Report: Road Safety Audit Stage 1**Report Title: Waterloo Square, Bognor Regis****RSA Team: Road Safety Answers Date: November 2020****RESPONSE REPORT**

Organisation: Bright Plan Ltd	Organisation: West Sussex County Council
Date: 16/11/2020	Date: 03/12/2020

Project Title:	Date:
Waterloo Square, Bognor Regis	06.10.2020
Document Title:	Drawn by / Checked by:
Proposed Site Layout Plan	SR / GG
Drawing Scale / Sheet Size:	Client:
1:500 @ A3	B5 ltd
Drawing Status:	Drawing Number / Revision:
PLANNING	18.103.400

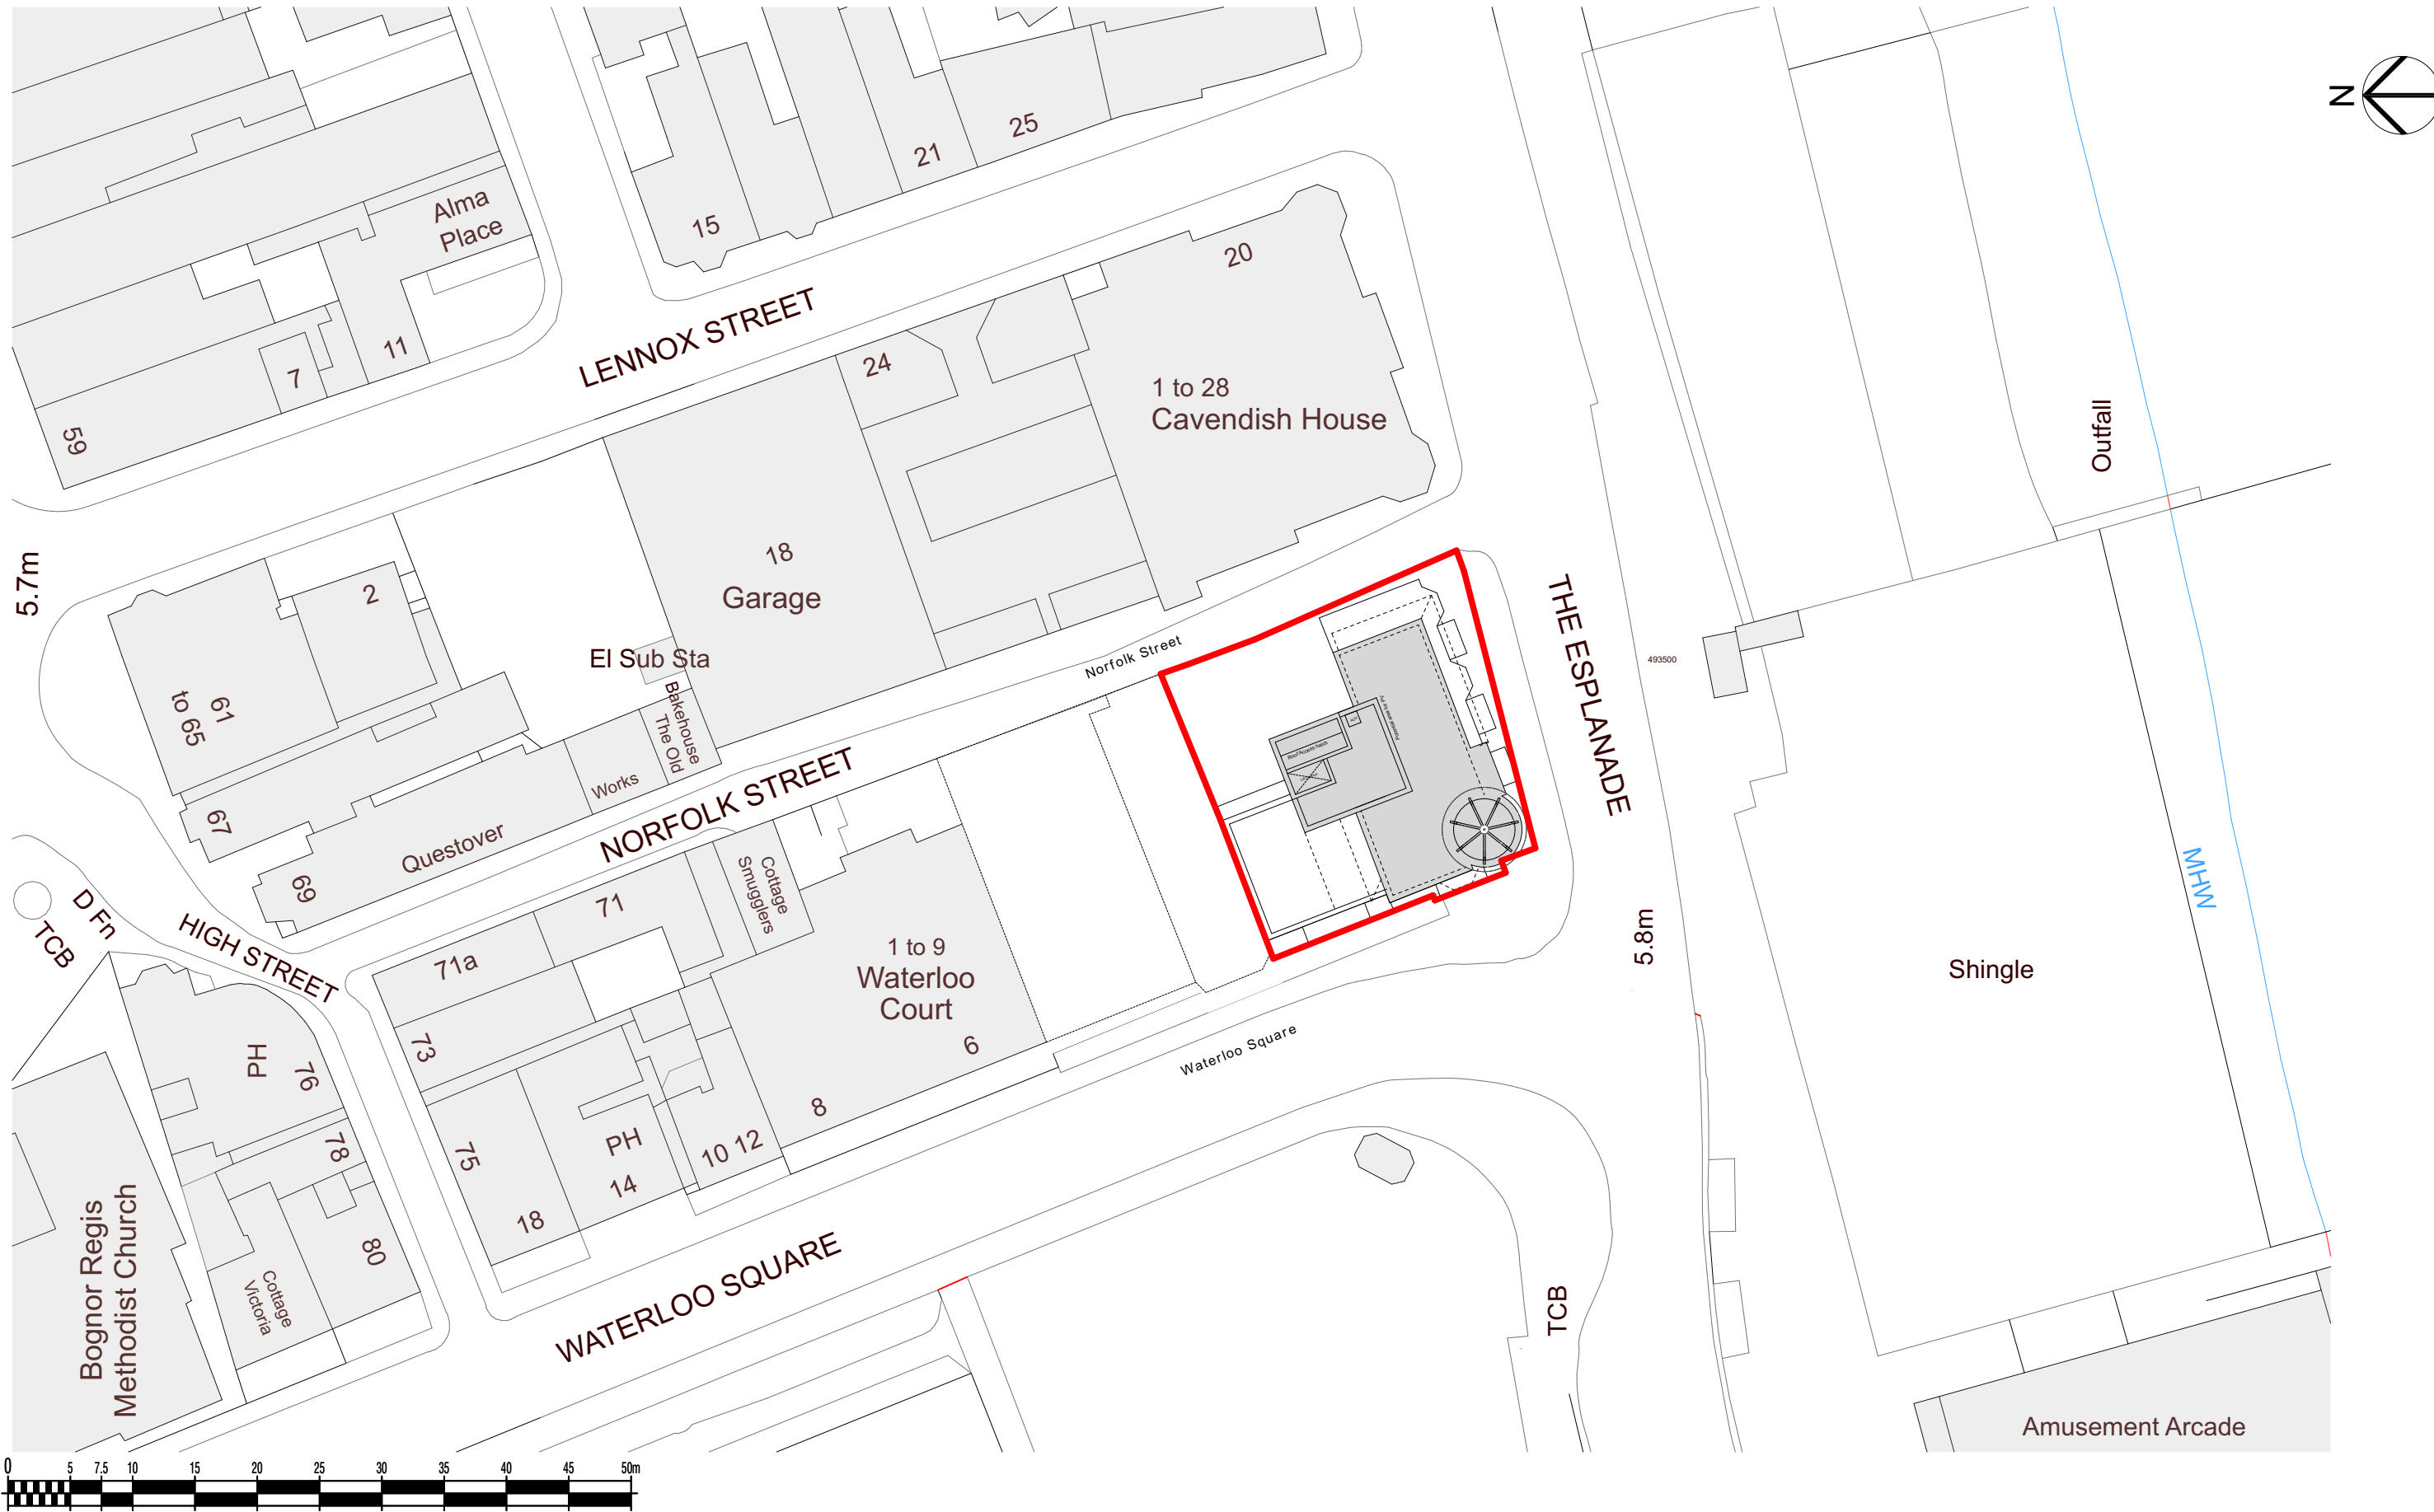
RSA Problem	RSA Recommendation	Design Organisation Response	Overseeing Organisation Response	Agreed RSA Action
The drawing does not indicate whether there will be a boundary treatment on the northern boundary on the site e.g. a wall or fence, between this development and the currently derelict site to the north. If the boundary treatment is low i.e. less than 1.05m in height, drivers exiting the proposed parking bays will be able to see over it, minimising the conflicts with vehicles approaching from the north on this one-way street. If the boundary treatment is too high, the visibility will be obscured, and the risk of a side impact increases, albeit slightly (vehicle speeds in this narrow street are low, and the parking spaces are for staff – trips to and from them will, therefore, be infrequent).	Any boundary treatment along the northern edge of the development should be kept below 1.05m.	Agreed The designer has proposed no boundary treatment in this location.	Agree that Designers Response addresses issue.	No further action required.
